Re: SP-07-00007

Re: Project Name (File Number): Wenger (SP-07-00007)

TO: Jeff Watson, CDS
FROM: Christina Wollman, Planner II *CW*
DATE: January 15, 2014
SUBJECT: Wenger Short Plat SP-07-07

SUBJECT: Wenger Short Plat SP-07-07

WENGER SHORT PLAT
KITTITAS COUNTY SHORT PLAT NO. 07-XX
PORTION OF THE NE 1/4, SEC.29 T.20N., R.14E., W.M.
KITTITAS COUNTY, WASHINGTON

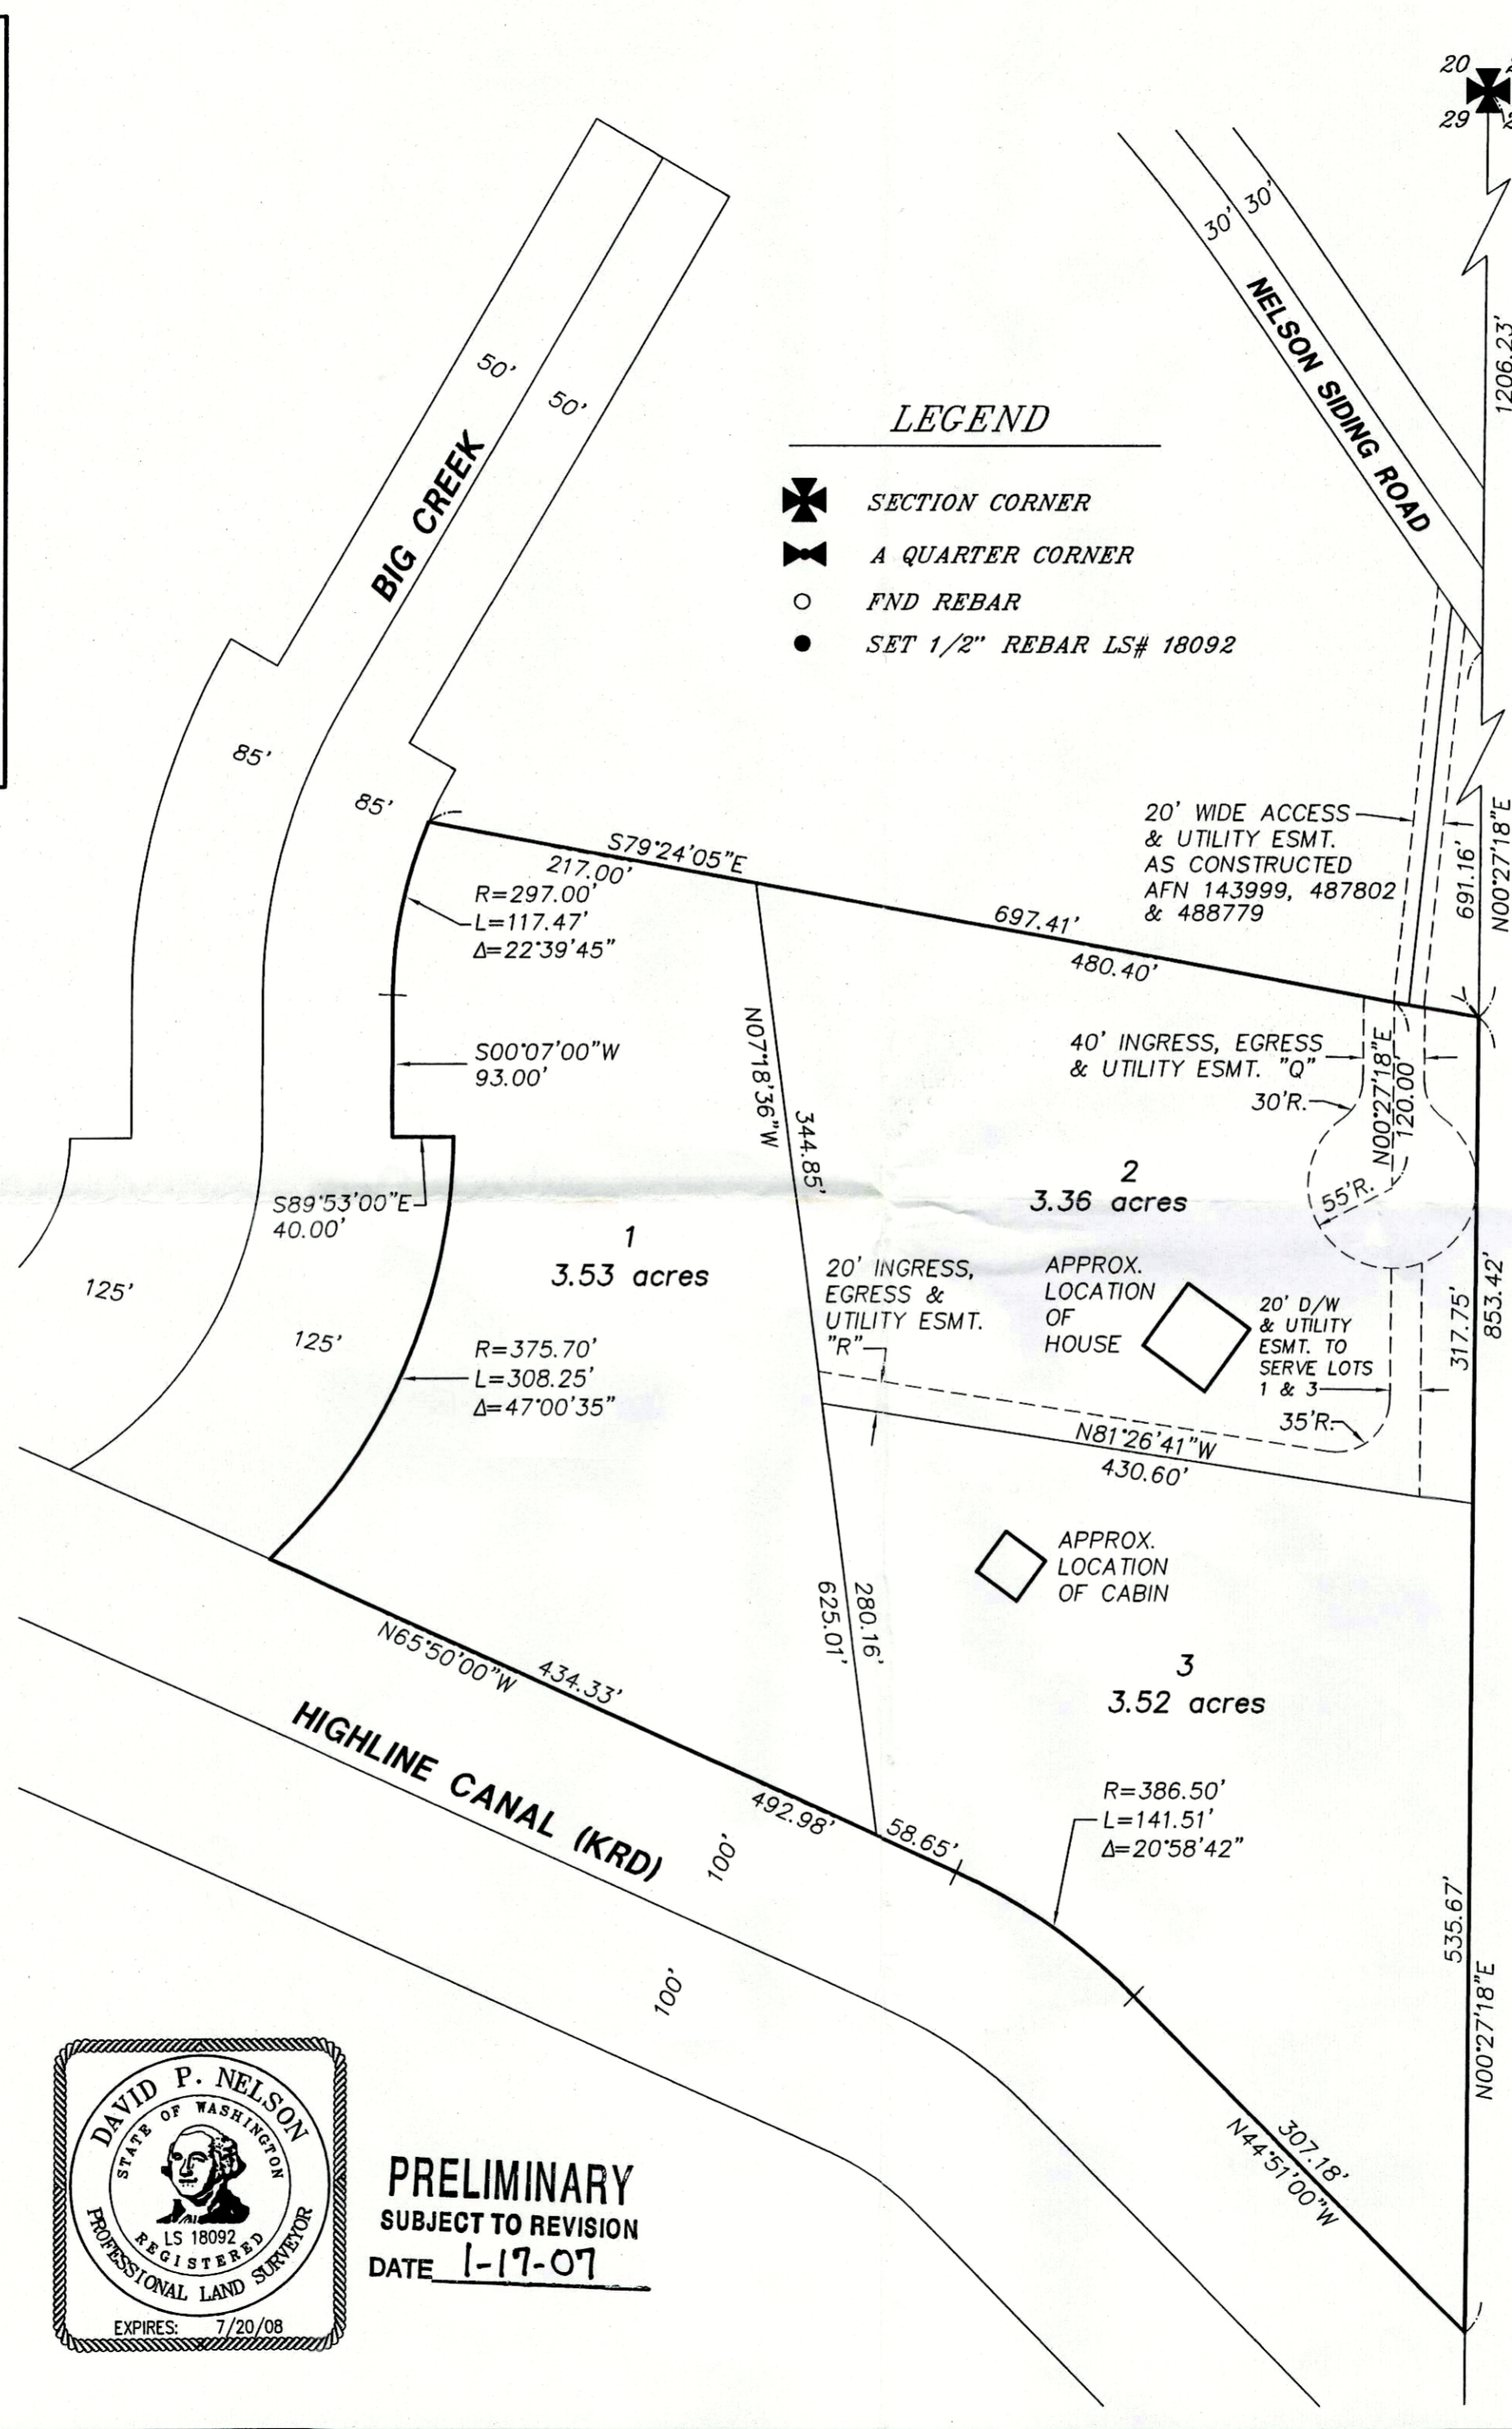
1. The 100-year floodplain must be shown on the preliminary short plat to ensure there is a buildable area outside of the 100-year floodplain on all parcels. This will prevent the landowner from needing to hire a hydraulic engineer to do a study. Unfortunately the parcel lines and floodplain boundaries on our maps are not accurate enough to make a visual determination.

2. For review purposes, the 200' shoreline jurisdiction must be shown on the preliminary short plat.
3. The location of Big Creek must be shown on the preliminary plat for reference.

4. The location of the KRD Lateral boundaries must be shown on the plat for review purposes and to ensure there is no encroachment.
5. Easement and actual driveway location for the road serving parcel 616536.

6. Revised road plans within the subject property, to show the relocated cul-de-sac and driveway. The easement within the subject property must be 60' wide and there cannot be more than two lots served off the end of the cul-de-sac.

7. Proof of a 20' access easement must be provided. The documents referenced on the survey (AFN 143999, 487802, 488776) do not provide this information. The documents state there is a 15' easement across parcel 469134 and an 18' easement across parcel 549134.
